-----  
Letter No.C2/24222/90, dated 4-7-'91

Sub: MMDA - Planning Permission - Proposed  
Construction of Factory building at  
P.No.A2, Mogappair Industrial Estate  
Village - Planning Permission issued  
leased on Local Body Earlier approved -  
Plan regarding.

- Ref: 1) Planning Permission No.5136/86,  
dated 28-10-'86 of Ambattur Township.  
2) Re.No.5839/90/F1, dated 11-9-'90  
from Ambattur Municipality.

AREA STATEMENT	Sqft	Sqm
GROUND FLOOR AREA	3650	339.53
FIRST FLOOR AREA	1375	127.91
TOILET AREA	162.56	15.12
TOTAL	5187.56	482.56

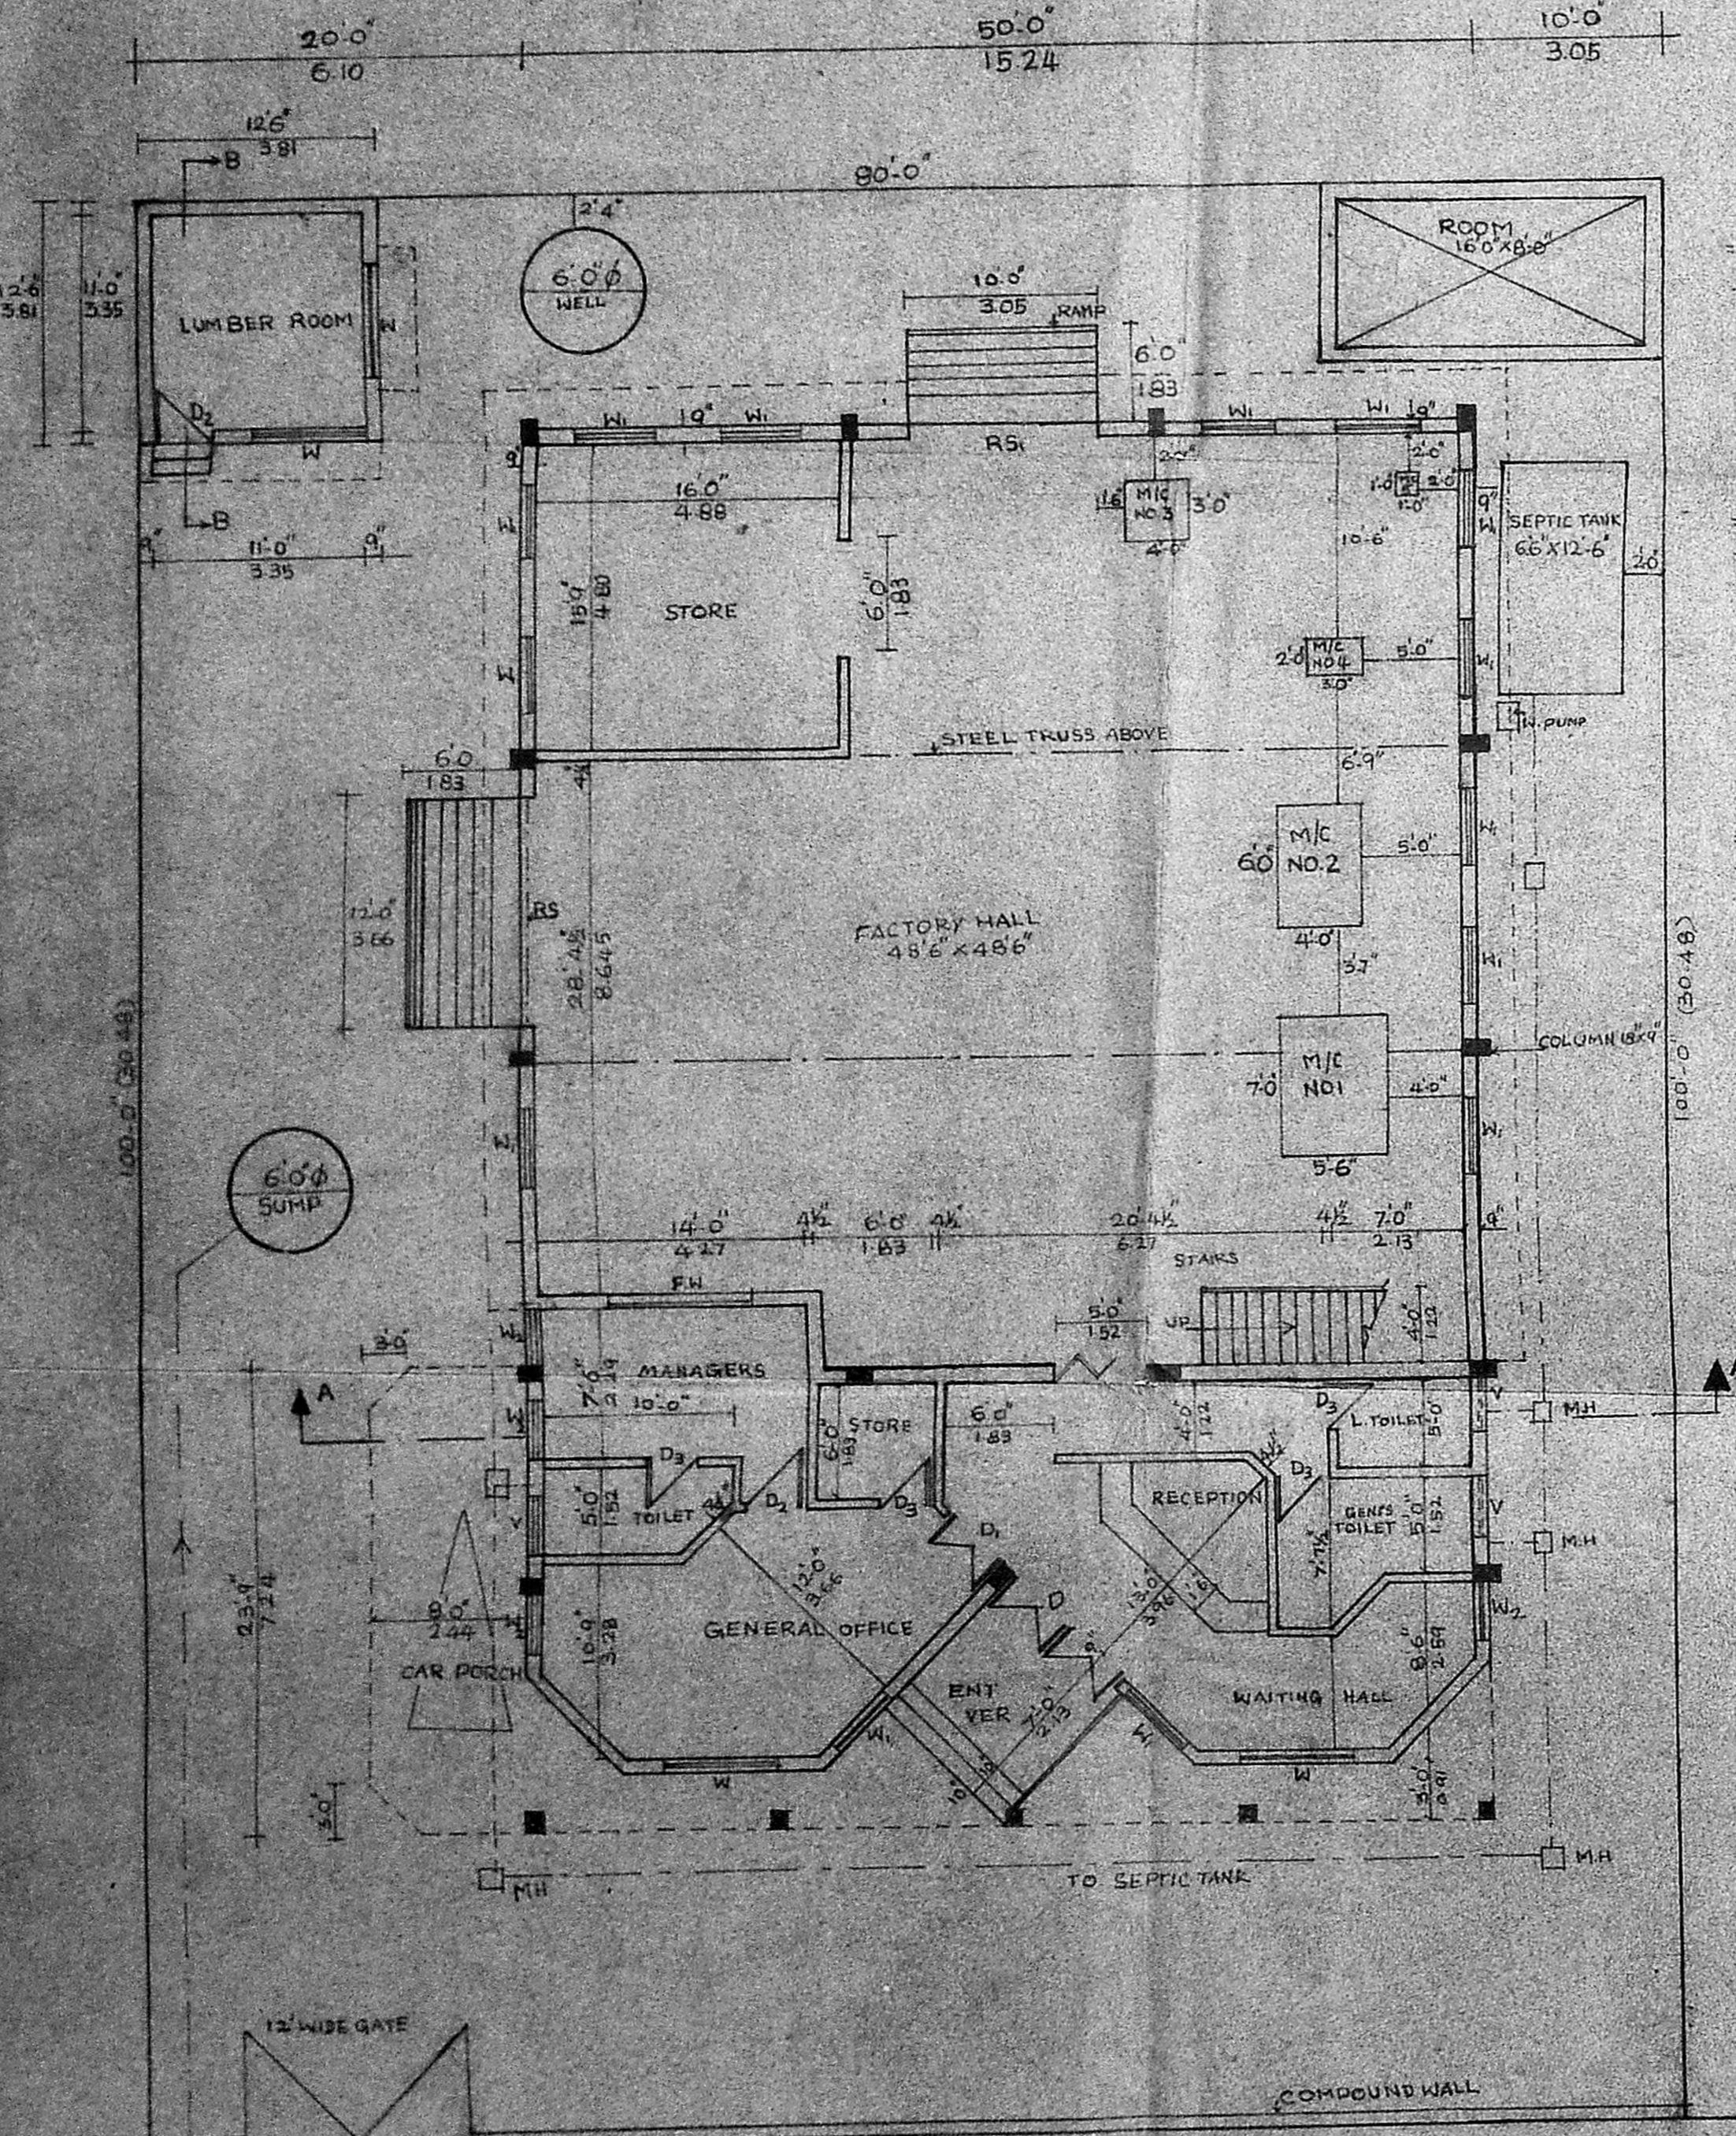
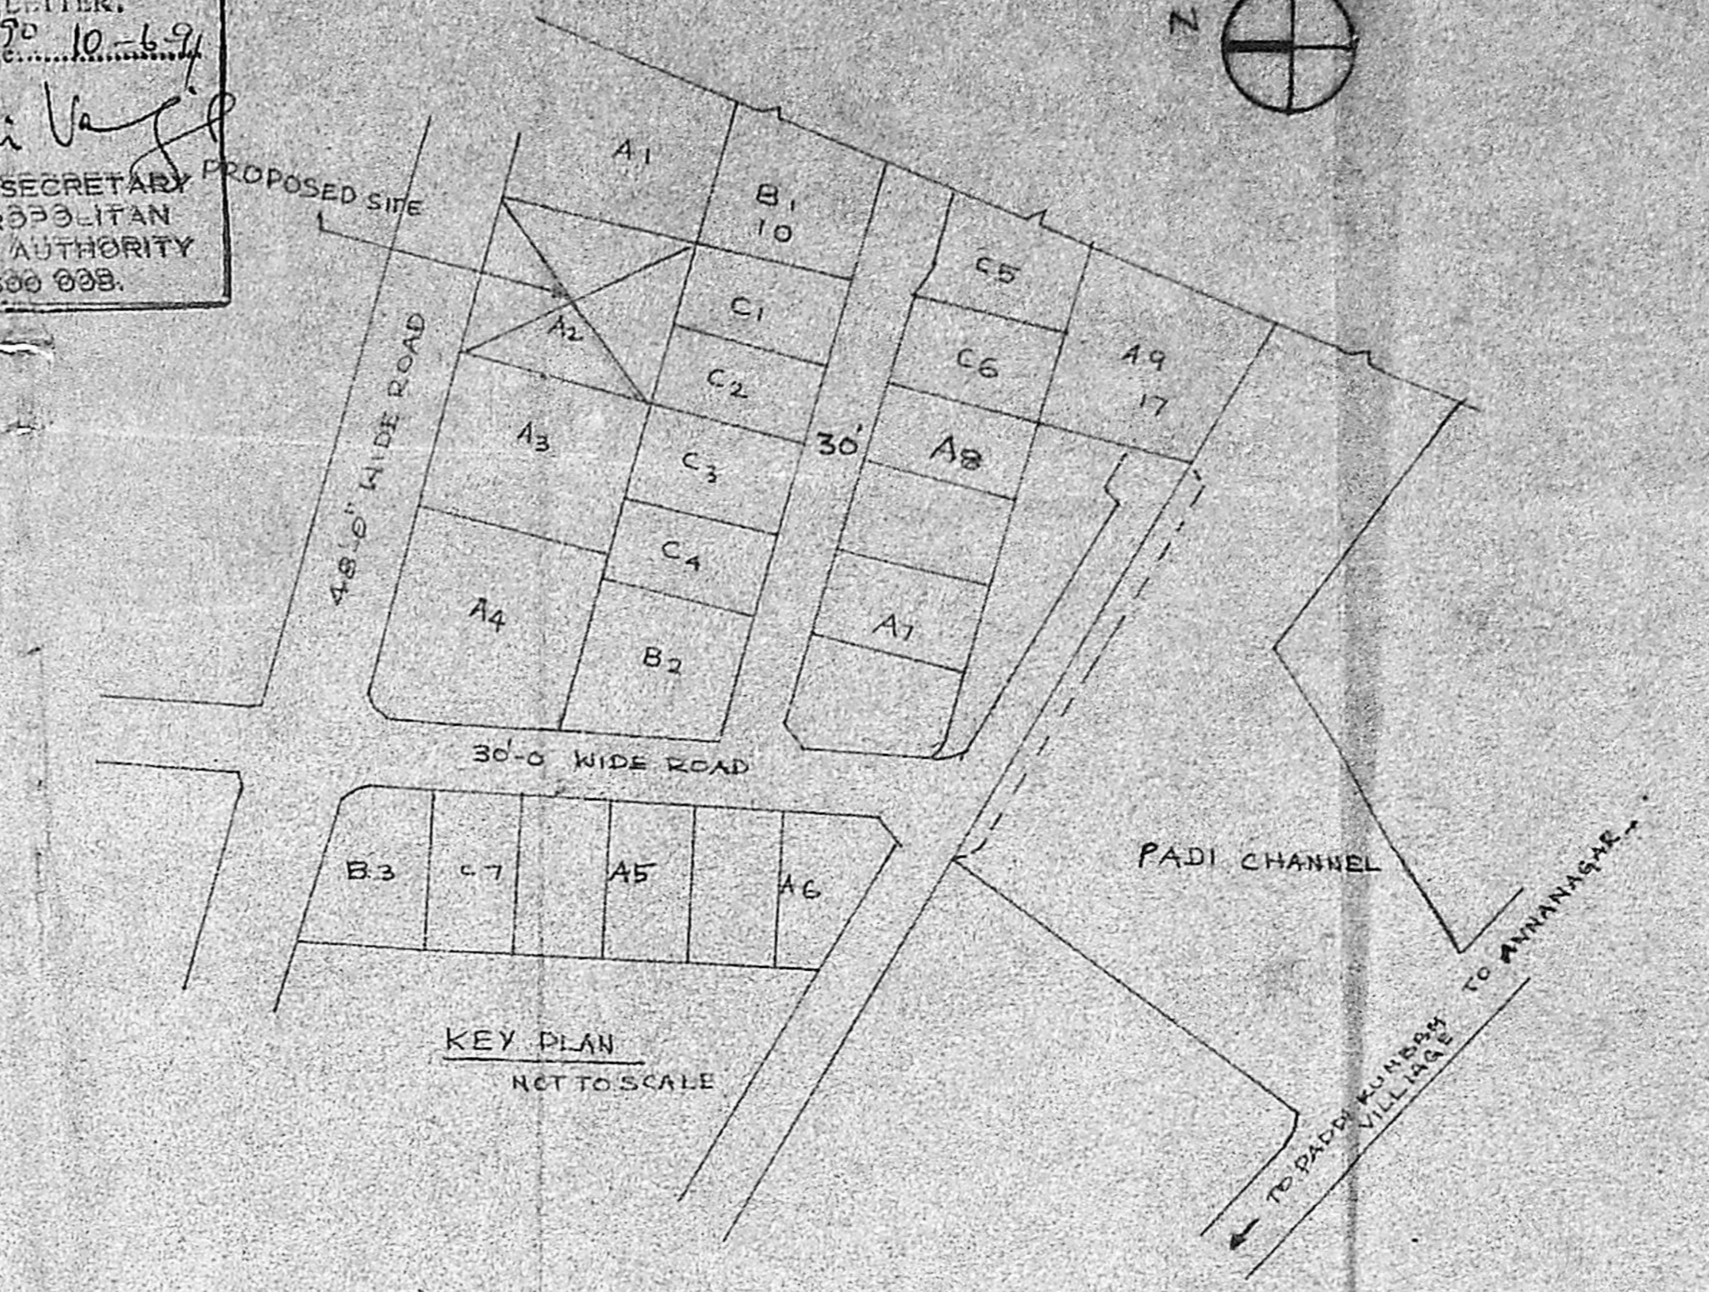
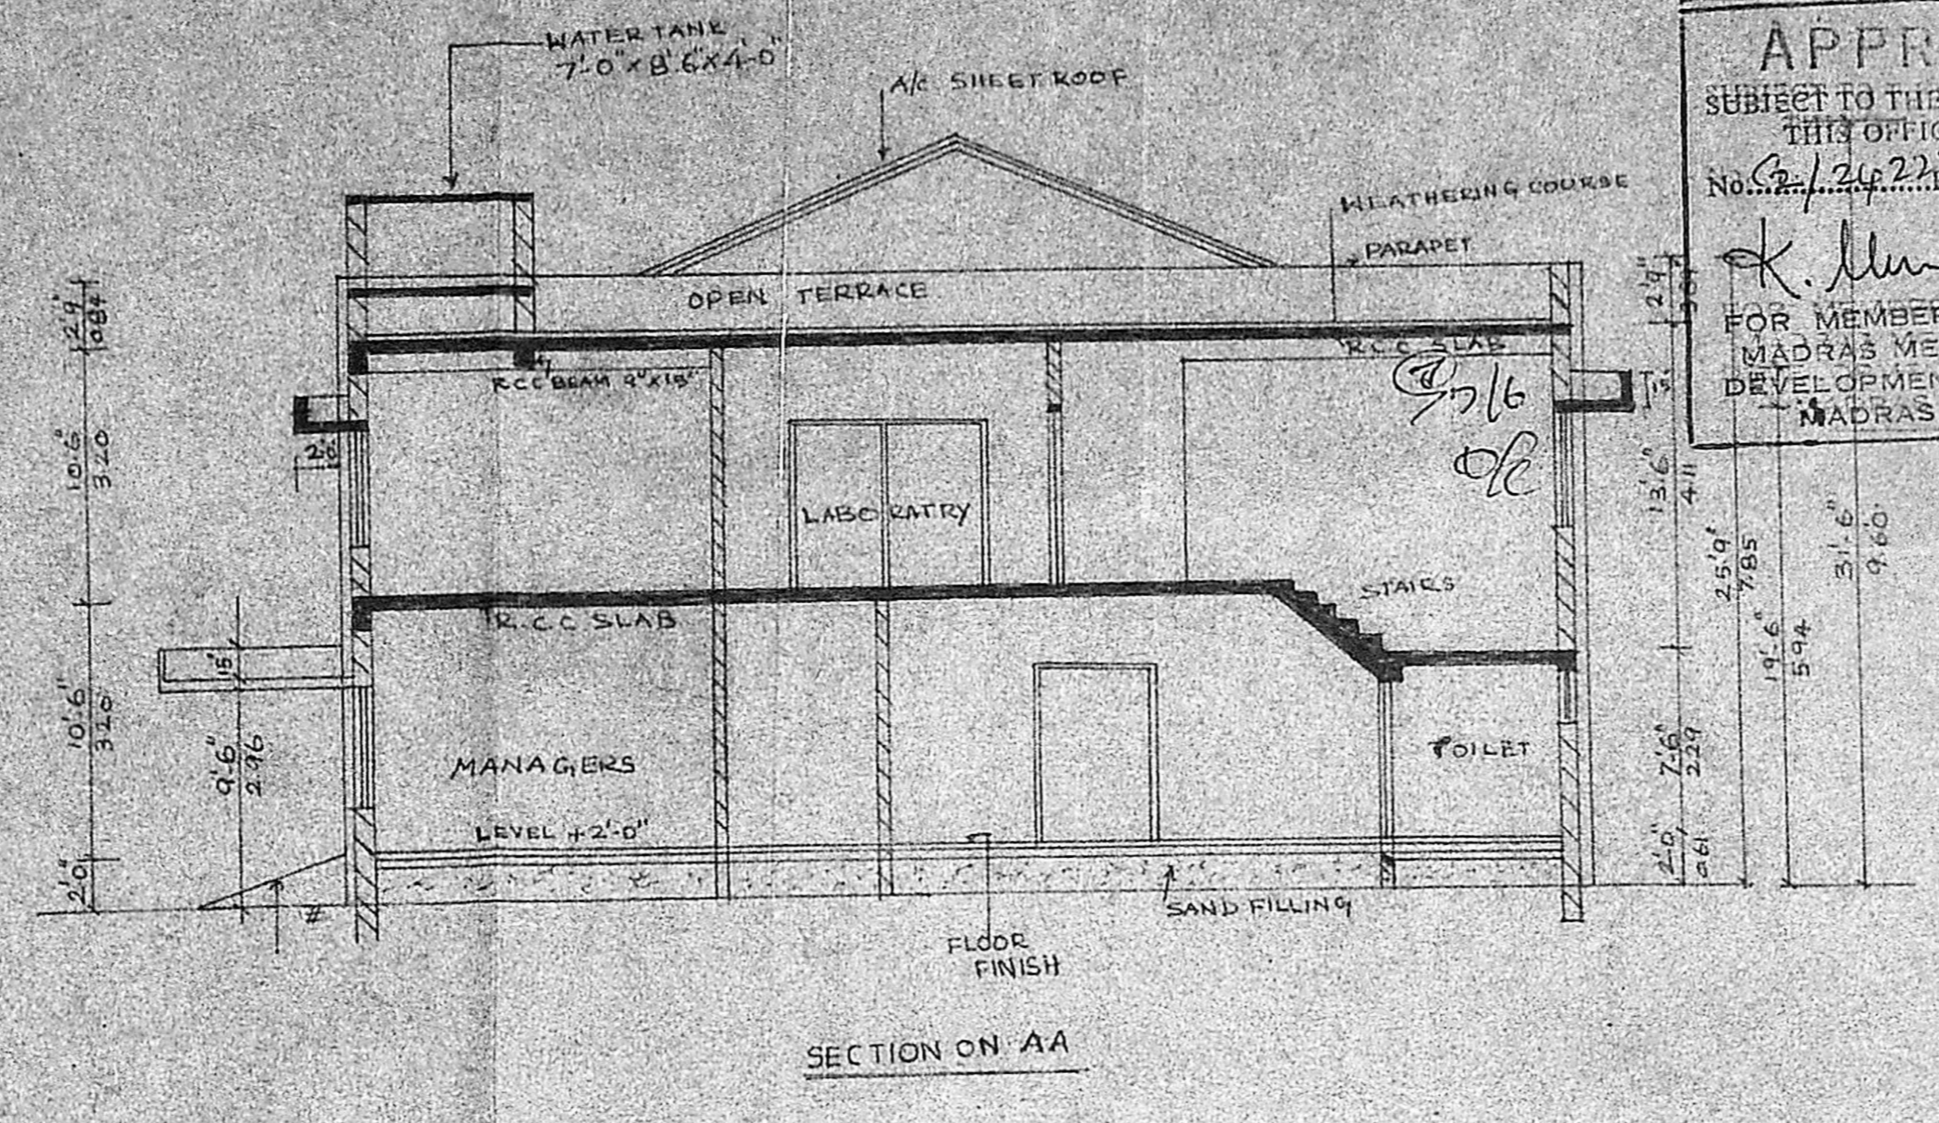
I invite your kind attention to the reference 2nd cited,  
wherein the Commissioner, Ambattur Municipality has submitted a  
Planning Permission Application of M/s. Lavanya Printing Inks  
at Plot No.2, Mogappair Industrial Estate for the proposed  
installation of 25.5HP.

2. While Scrutinising the paper, it has been found  
that the Ambattur Municipality has already issued a Planning  
Permission (reference 1st cited) for the construction of the  
Industrial building for manufacturing ink to ~~comparing~~ in *Said*  
violation of Development Control Rule 11(d) Parameter and *Company*  
Front Set Back and side set back requirements. Since the  
construction, have already been approved by Local Body violating  
the Development Control Rule, Para Meters, this Authority has  
been forced to an embarrassing situation of approving the installation  
of electric motors in the said premises.
